Residence
8213 Old US 421, Broadway, NC 27505

Foundation Damage

Inspections

S-1.2
Foundation Section
Detail

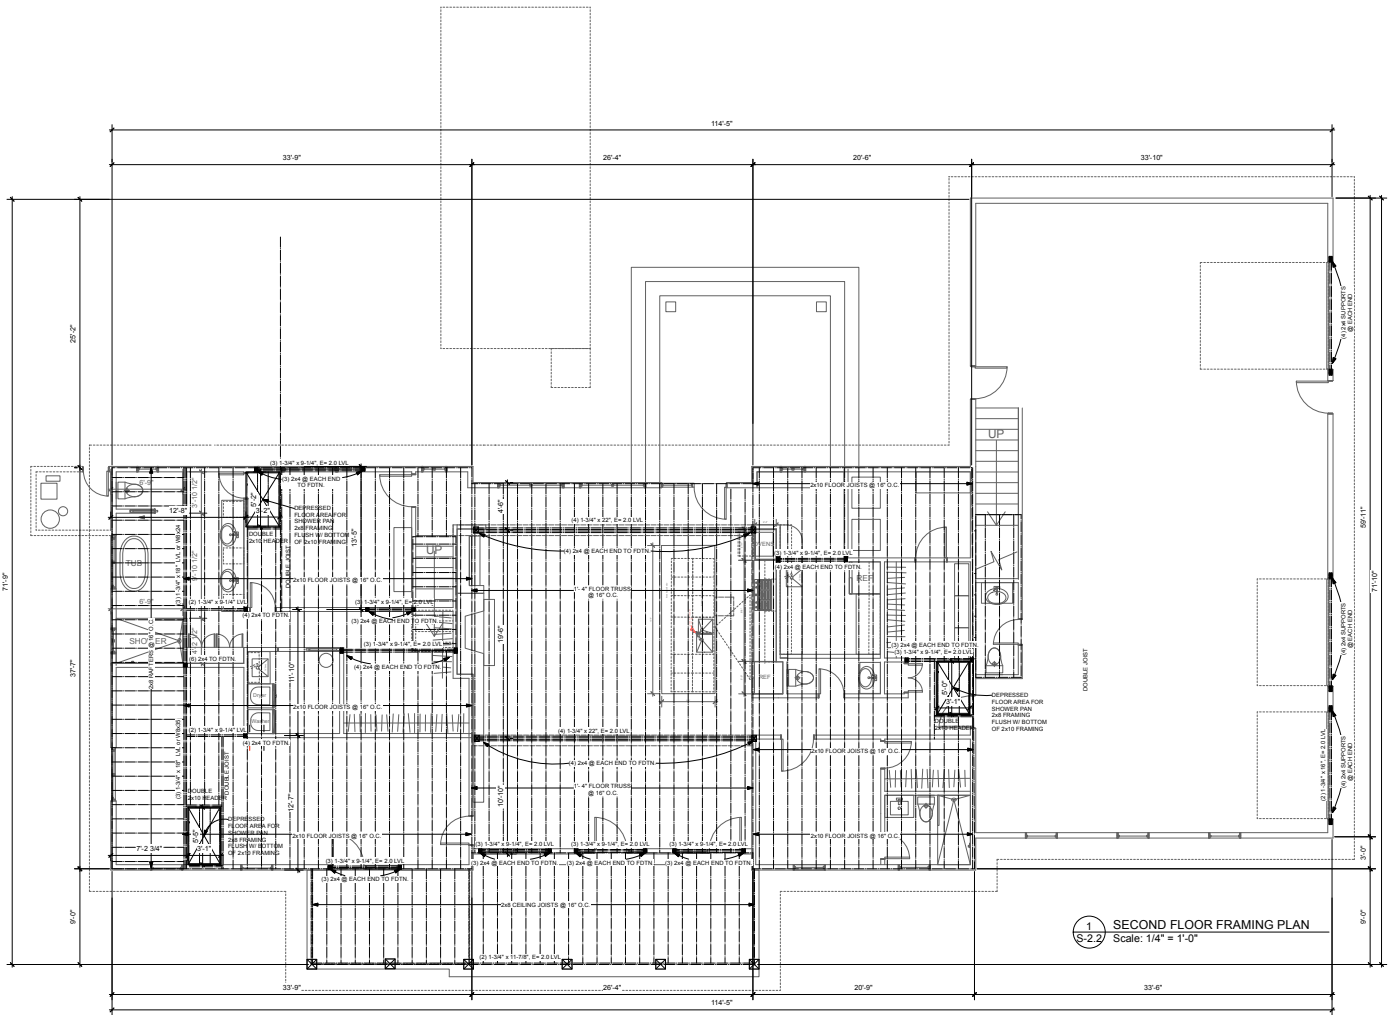
I have reviewed the damage done to the foundation. Since this is a vertical load condition and the steel reinforcement has not been damaged or changed, I recommend reforming the foundation and placing a new concrete cap over the damaged area. The face will need to be troweled to finish the joint between the existing and the new placed concrete for cosmetic look. The broken insulation will need to be repaired or replaced as needed to create a continuous layer of insulation.

After completed the foundation shall meet the structural requirements per the documents.
